CITY OF ALBUQUERQUE

Re: Carlisle and Menaul
Traffic Impact Study (H16D083F)
Submittal dated September 19, 2024
Via email cvermillion@bhinc.com

The City of Albuquerque Planning Development Transportation Section received a Traffic Impact Study (Study) dated September 19, 2024 and provides the following discussion and comments.

PROPOSED STREET SECTION			
CARLISLE AND MENAUL			
DRAWN BY:	JR	DATE:	01/22/2025
CHECKED BY:	KK	BHI PROJECT NO:	20240281
		SHEET NO.	---

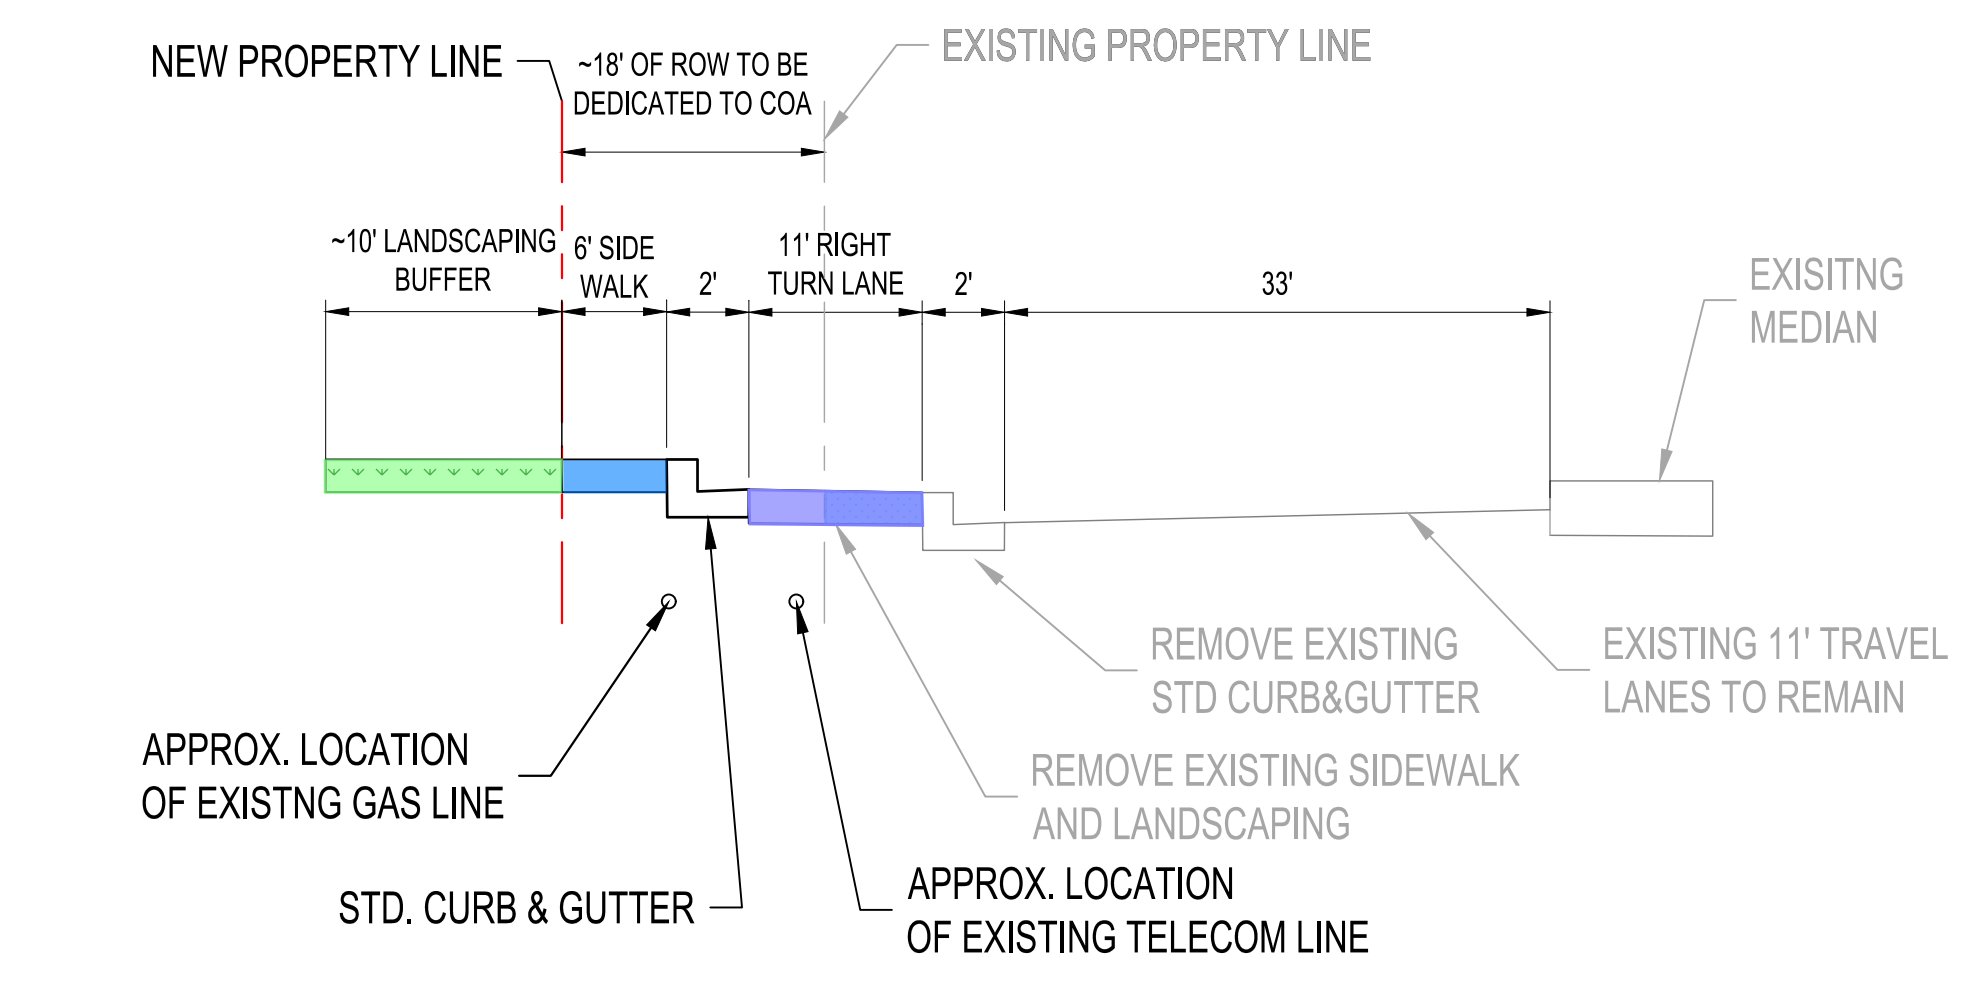
2. In agreement with the Study that bicycle crashes in this area may be decreased by the installation of bicycle infrastructure, NMDOT comments, MRCOG's Long Range Bikeway System and bike lane Improvements/pending improvements on Carlisle Blvd south of I40, the project is to construct a 6' wide bike lane with a 2' buffer along its Carlisle Blvd frontage.

3. 2026 AM build volumes at Carlisle/Access 3 and Menaul/Access 2 appear to warrant a right-turn lane and may reduce crashes.
4. Agreed that Carlisle Blvd may benefit from a sidewalk buffer. It appears the site is being replatted, so incorporating a sidewalk buffer into the revised southbound Carlisle Blvd street section may not be an issue.

5. As part of revising the Carlisle Blvd southbound street section to accommodate the bike lane and deceleration lane, lane widths should be reviewed/proposed. Lane widths to be a maximum of 11' wide.
